**From:** Slingo, Bradley [REDACTED]  
**Sent:** 10 October 2017 16:33  
**To:** Sue Howell; Michael Eastham  
**Cc:** Kennett, Darren  
**Subject:** RE: Swanbourne Park - AL/82/12 - LEAP/LAP Proposals

**Subject:** \*EXTERNAL: RE: Swanbourne Park - AL/82/12 - LEAP/LAP Proposals

Thank you for submitting LAP and LEAP proposals dwg BSH17576 31 A

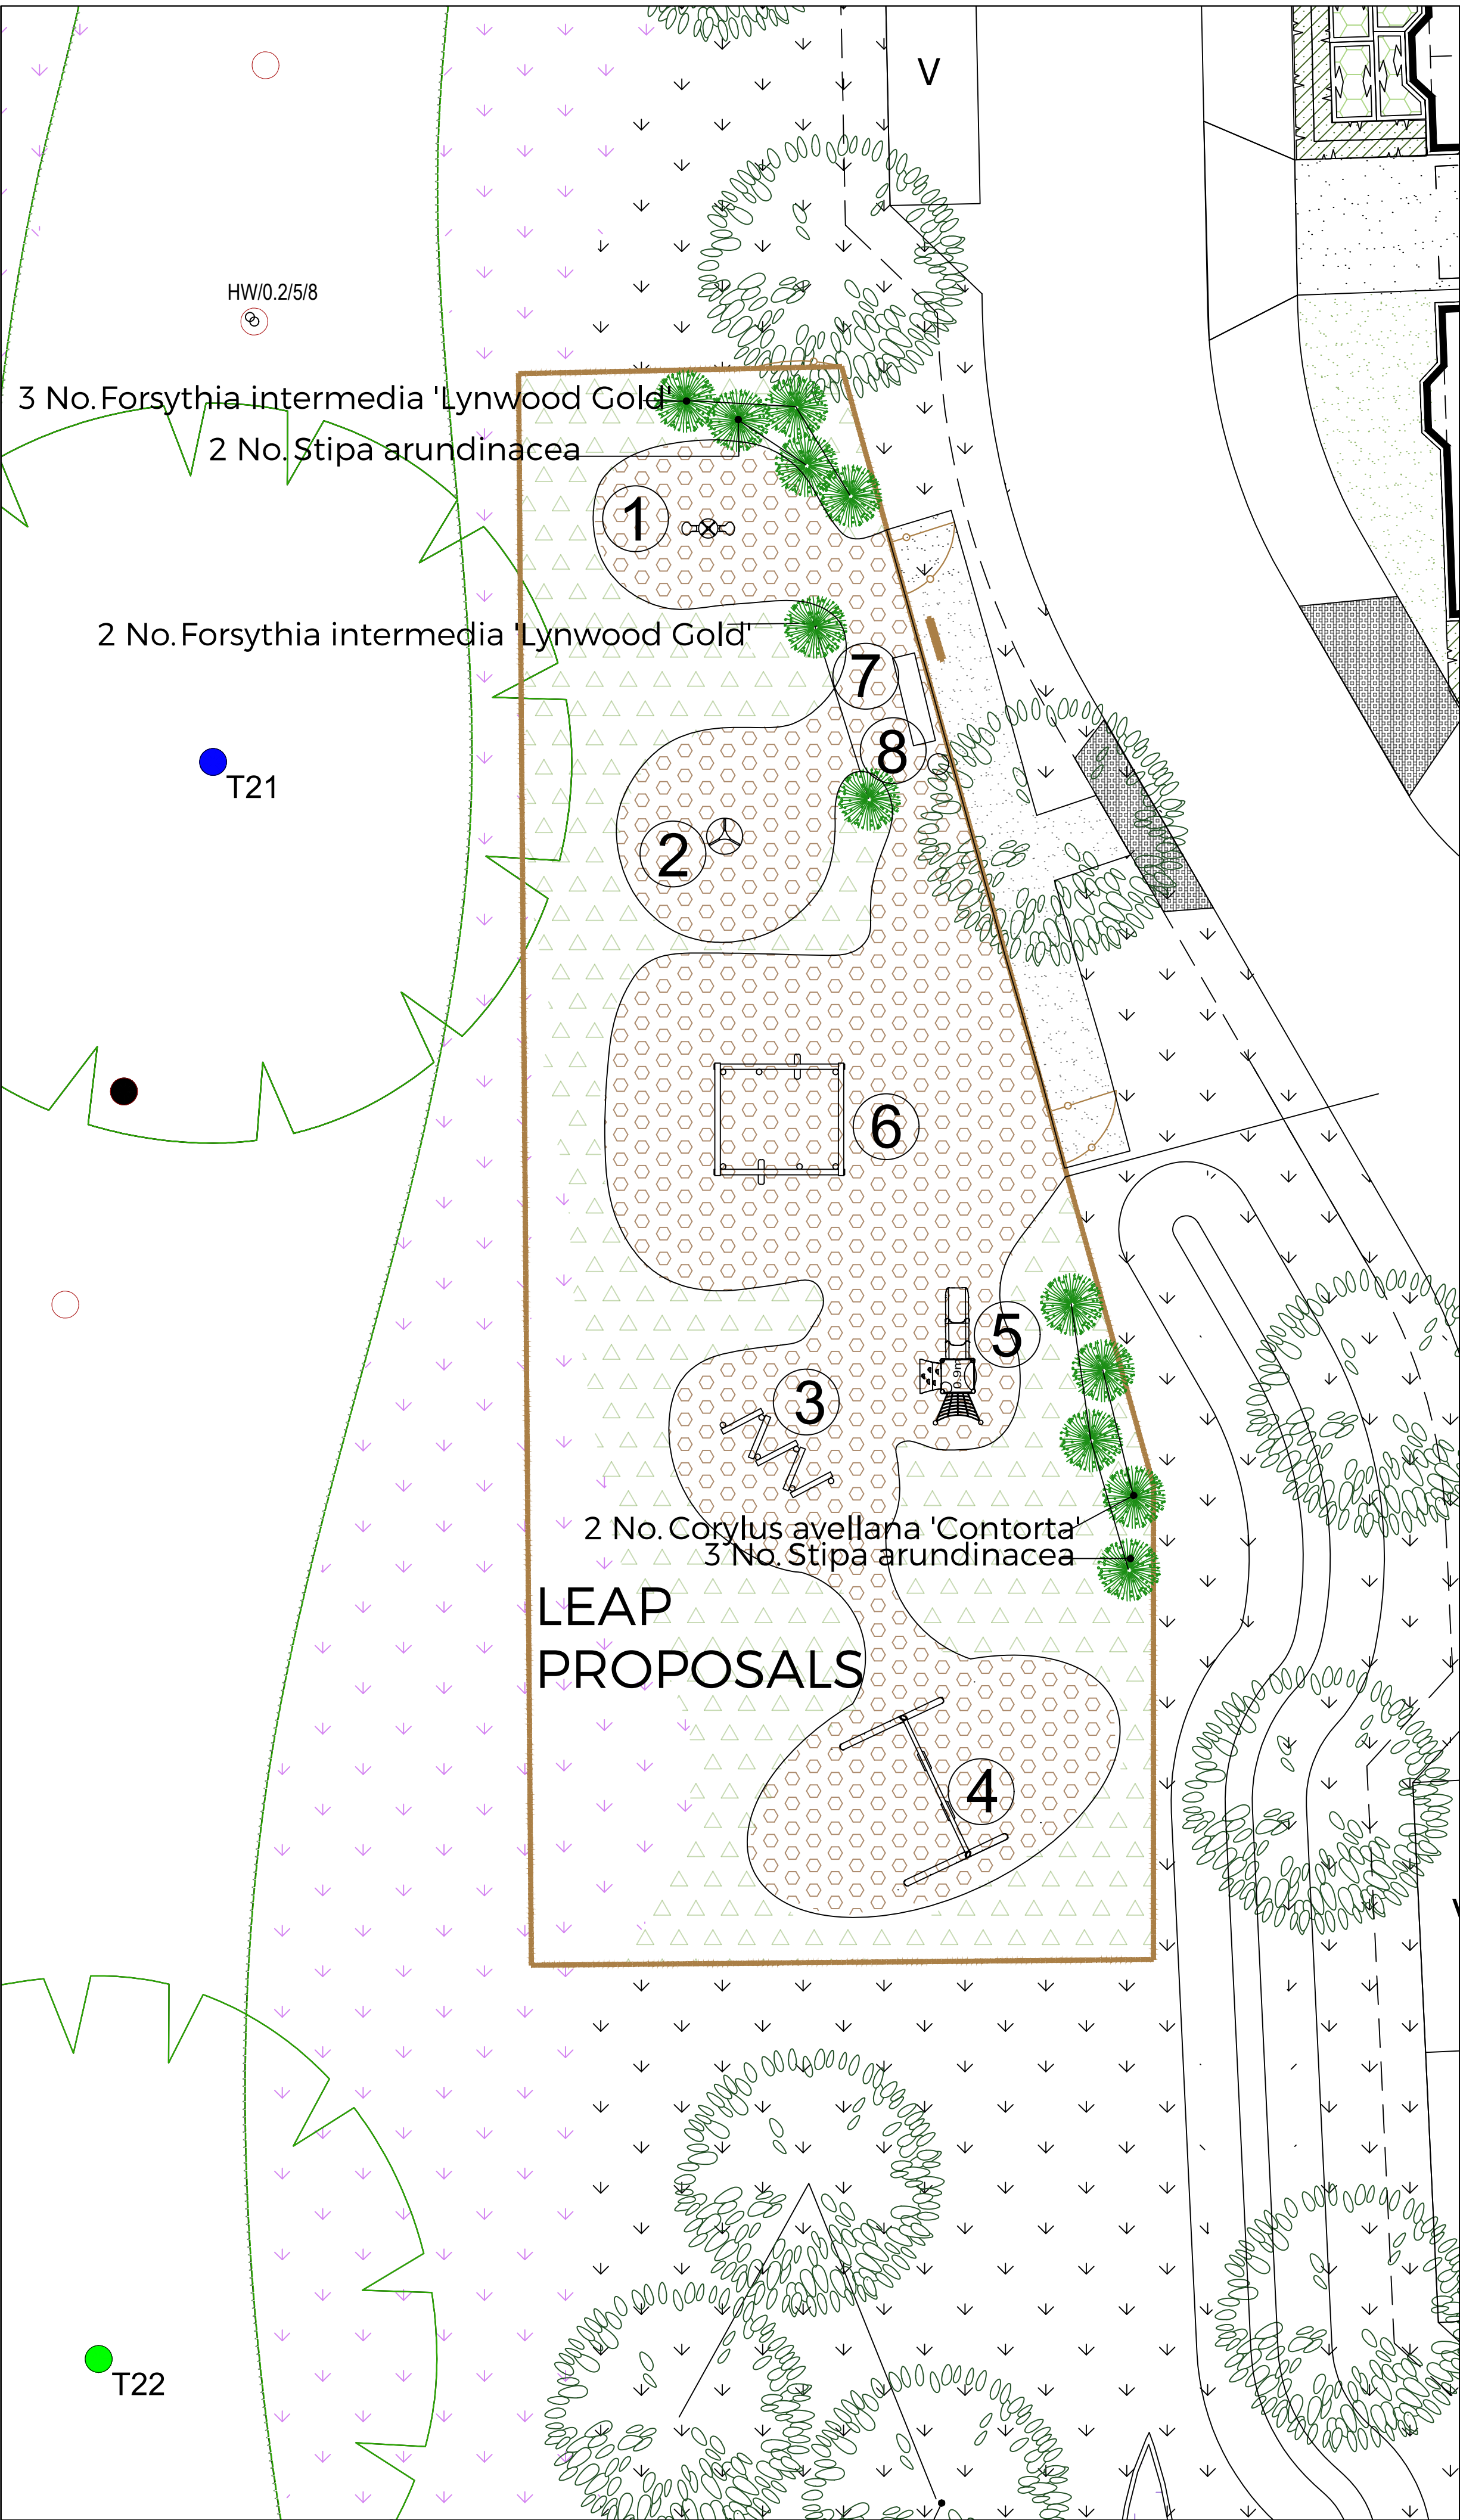
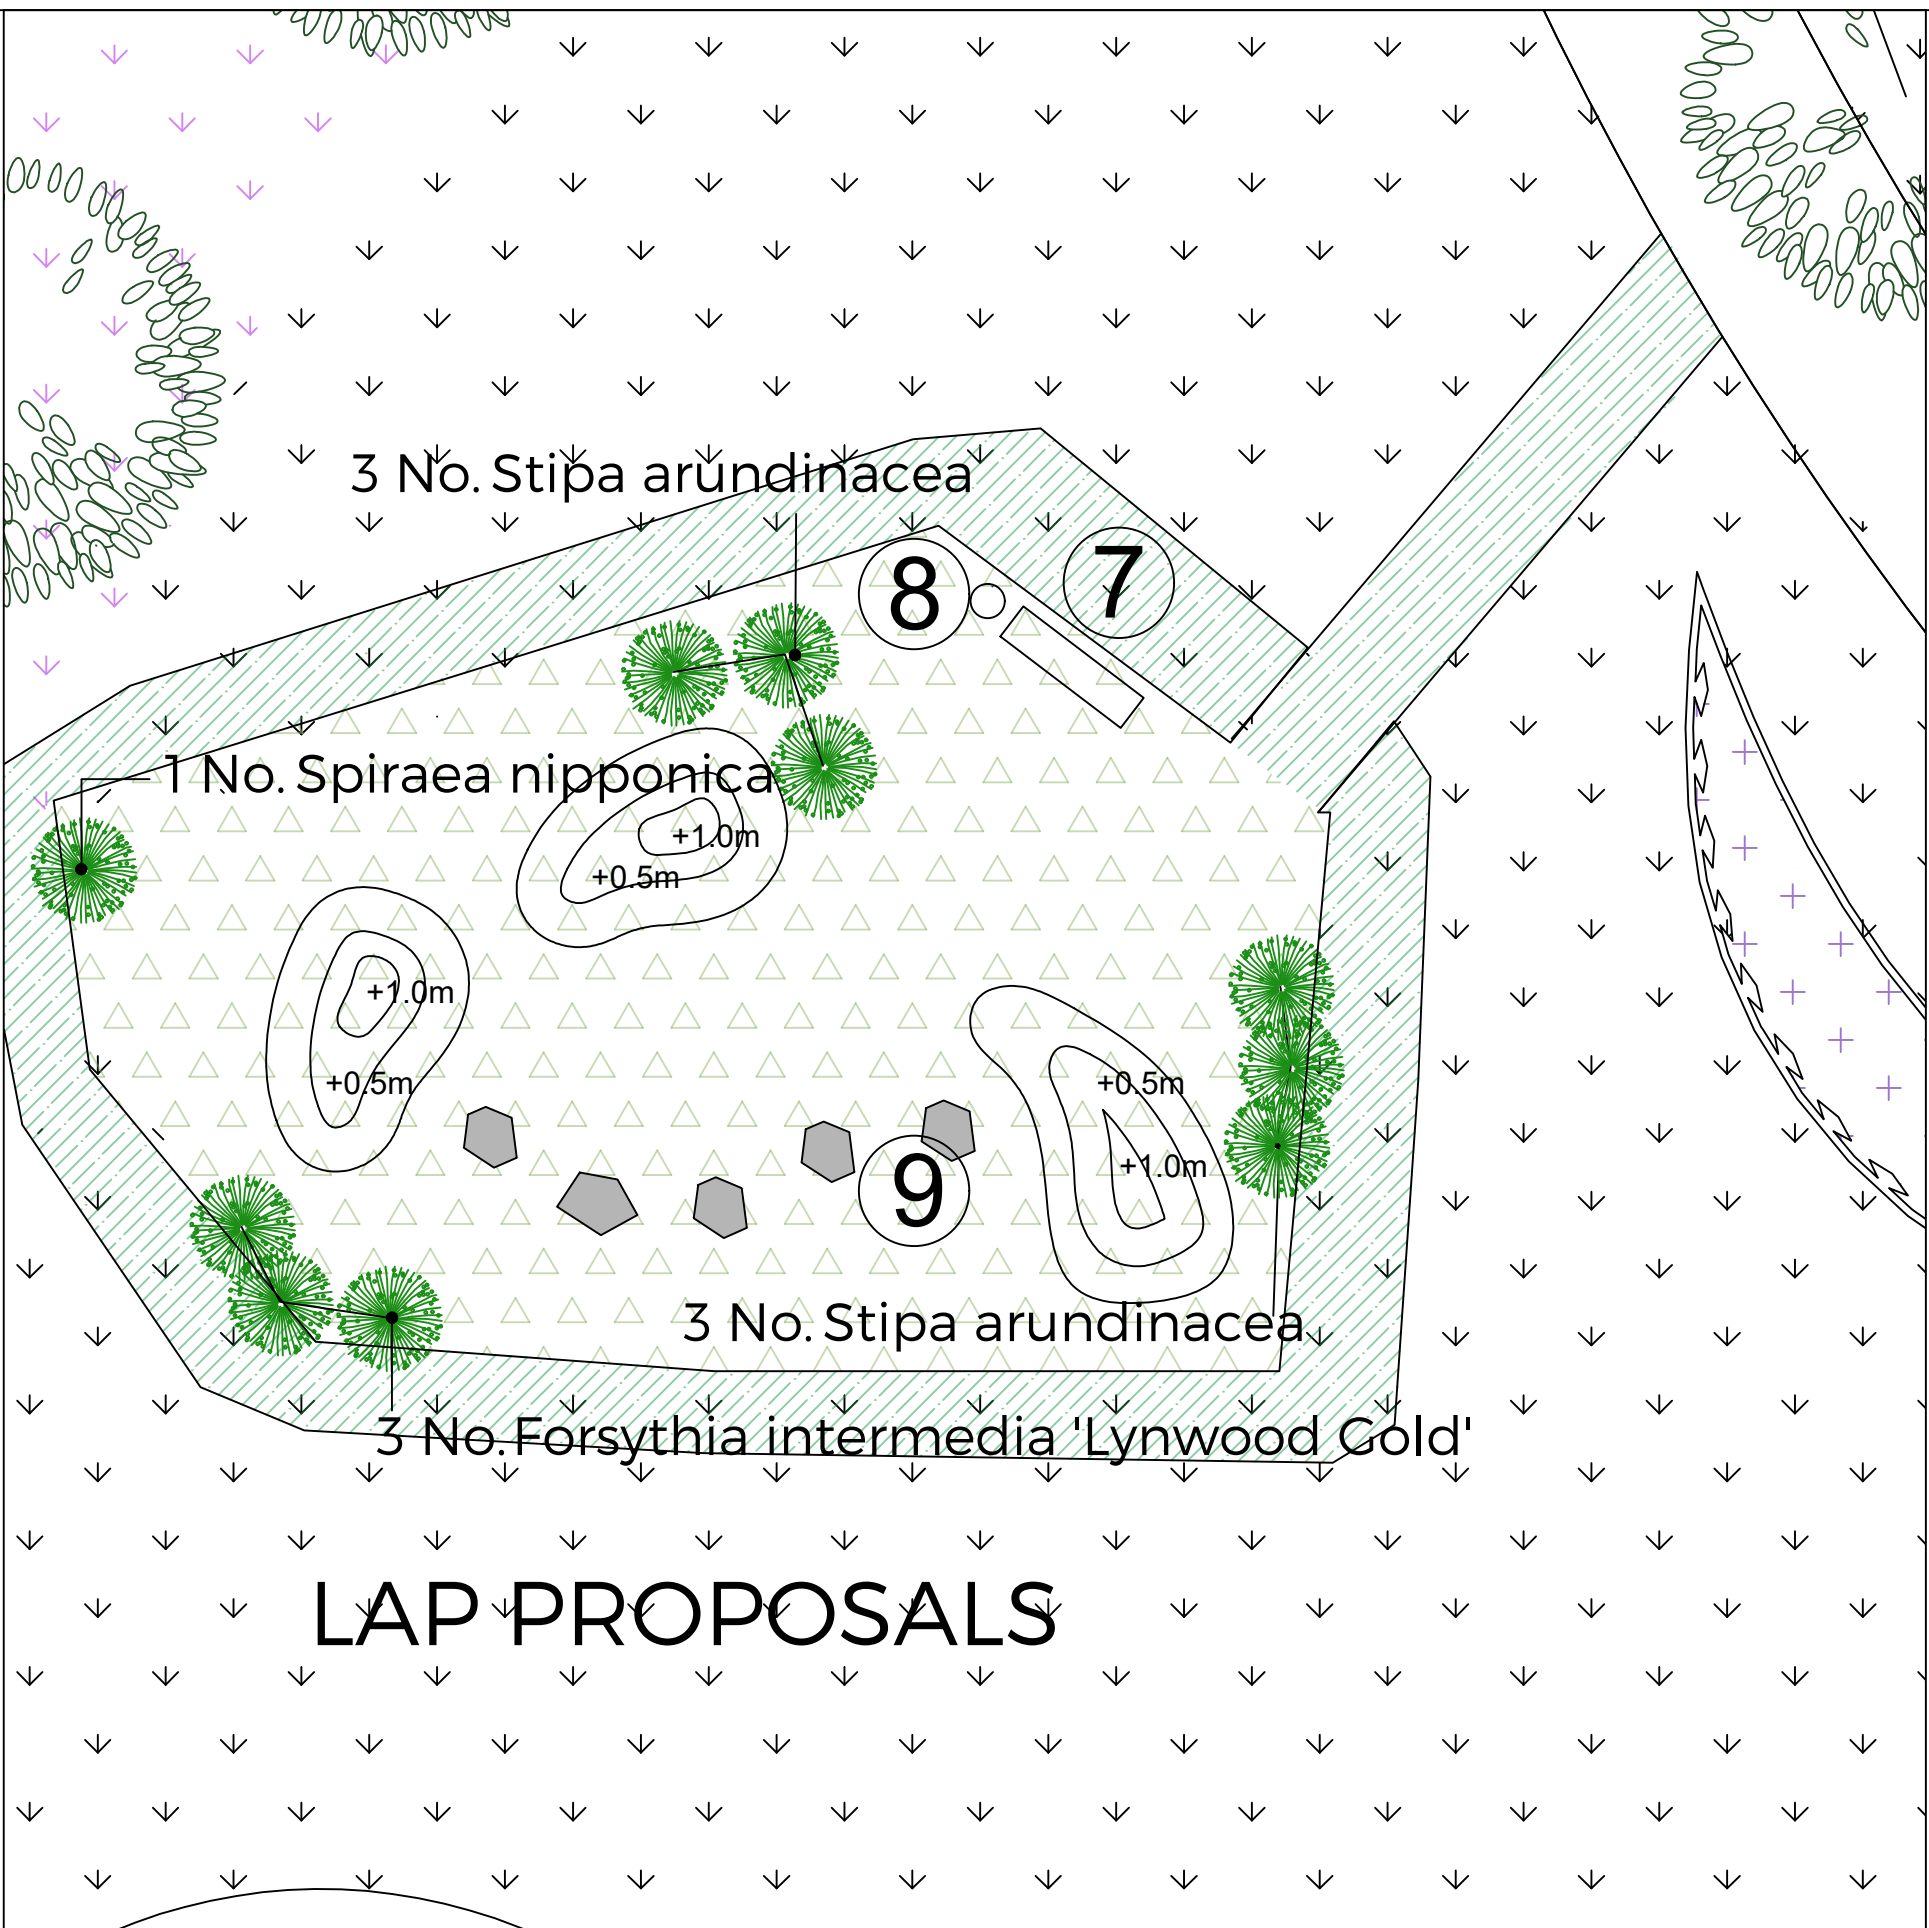
LEAP Needs to provide a minimum of six experiences and be designed and laid out specifically for children who are beginning to go out and play independently. This should provide stimulating and challenging play experiences. I do not believe that the offer being presented caters for this criteria, therefore please reassess the offer here, amend and re-submit. Gates when incorporated into a fenced areas are better to be accessed via pathways to make these more user/wear friendly. Please detail fence type where indicated for fencing.

LAP This should be a small area of open space – Not fenced specifically designated and primarily laid out for very young children to play close to where they live. This we do not need to see equipped but to have some natural play experience ie mounds, boulders natural play. The provision of a seat in this area is still acceptable. Please remove formal fenced and tarmac detail, amend and resubmit.

I am sitting down with some internal parties to run through your comments tomorrow. I will submit a revised design for the LEAP/LAP thereafter.
